Recommendation Report for Planning Permission for Works or Extension to a Dwelling

REF NO: AW/247/19/HH

LOCATION: 12 Blondell Drive
Aldwick
PO21 4BQ

PROPOSAL: First floor rear extension.

Title
Plans as Proposed
First Floor Rear Extension

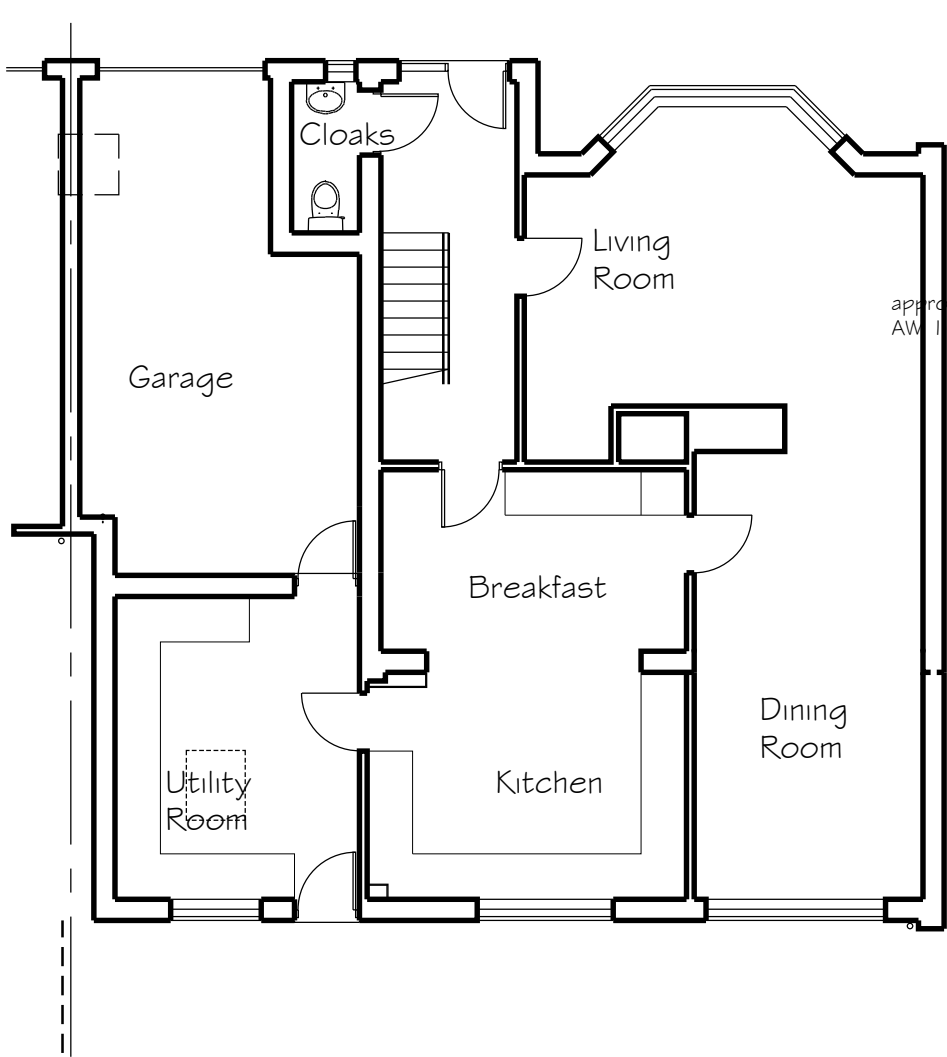
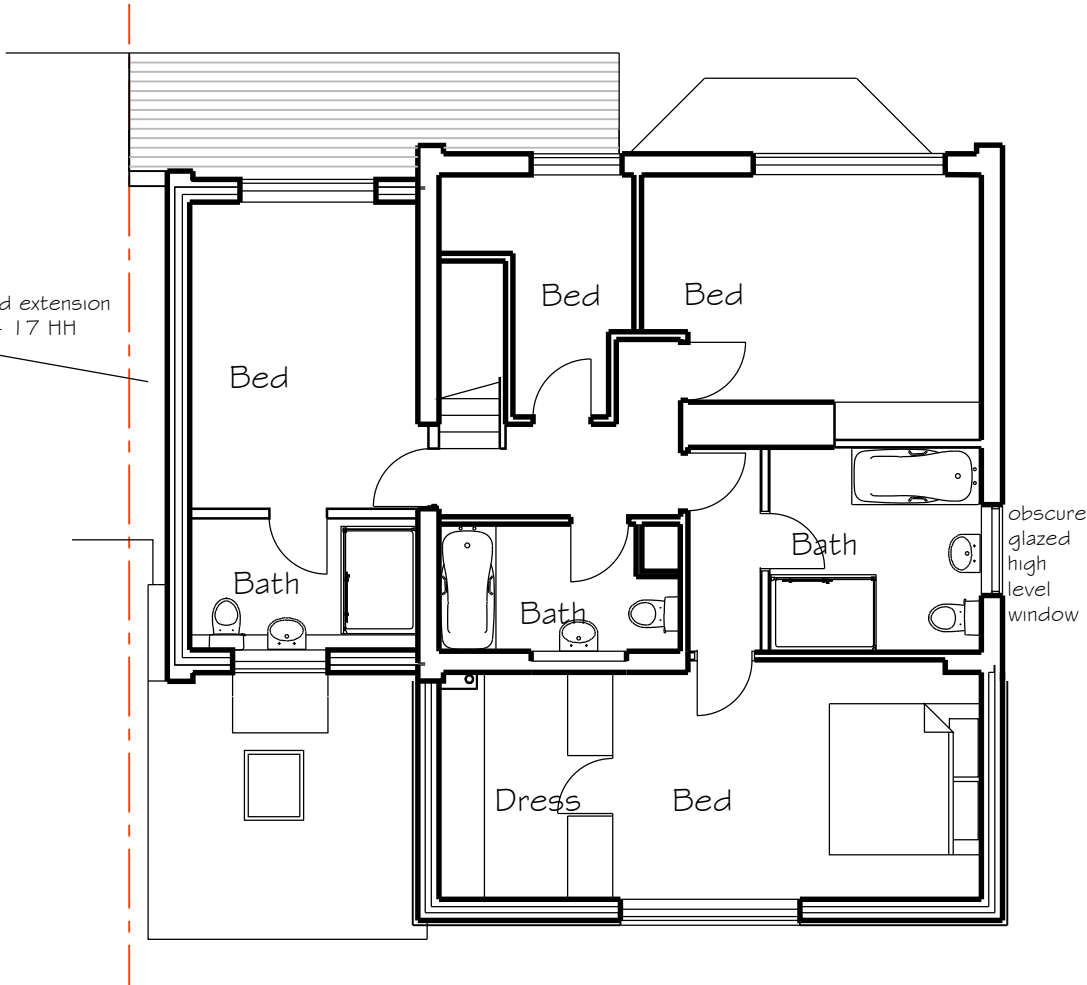
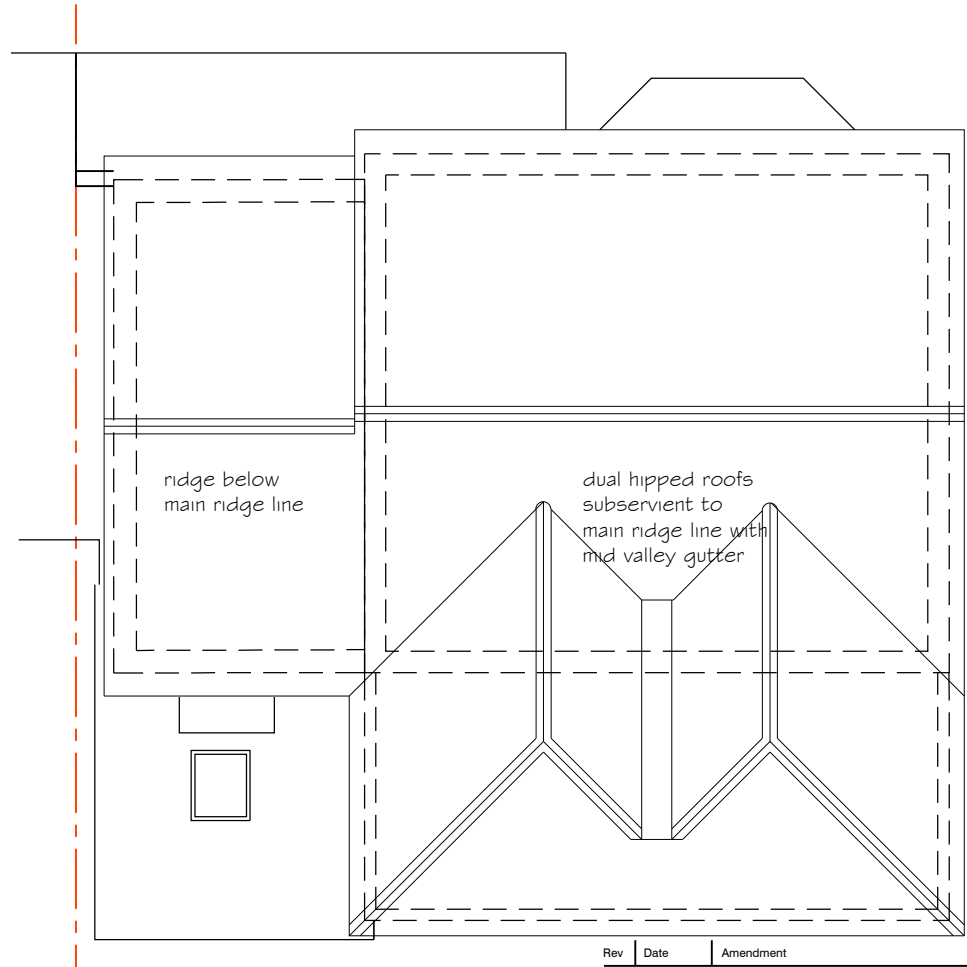
The proposal will construct a first floor extension to the existing rear addition which has a depth of 5.3m. The height will increase from a lean to roof to a hipped roof to match the eaves height of the host dwelling with a pitch height 0.5m lower than that of the host dwelling. Whilst this adds bulk to the rear, the dwelling to the north west has a pitched roof addition at the boundary and as a result the development is not considered to appear overbearing or overbearing upon this property. The neighbouring property (No. 14) has a window to the side of the dwelling that faces the proposed, this is not the main window to the room. As well as this the neighbouring window has views that are currently obscured by the existing property therefore, the proposal will not have a demonstrable impact on the views or overshadowing.

Title
Elevations as Proposed
First Floor Rear Extension

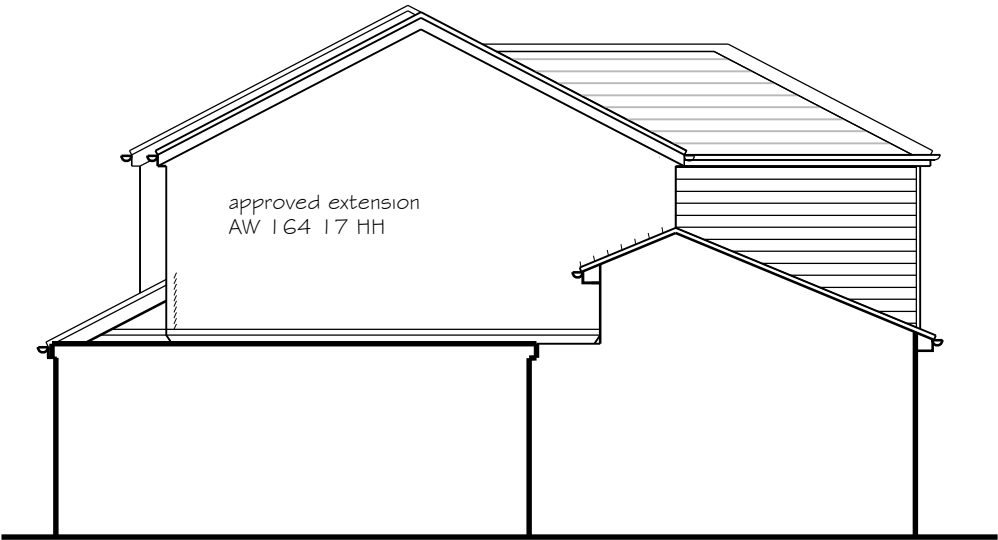
The extension is sited to the rear of the dwelling and will not be visible from the street scene. Whilst the addition adds bulk to the rear elevation, the proposal is considered well integrated with the dual roof hipped to match that of the existing. It is also considered proportionate to the size of the dwelling with materials to match.

There will be 1 additional window facing north west however, this serves the garden and is not considered to result in adverse overlooking.
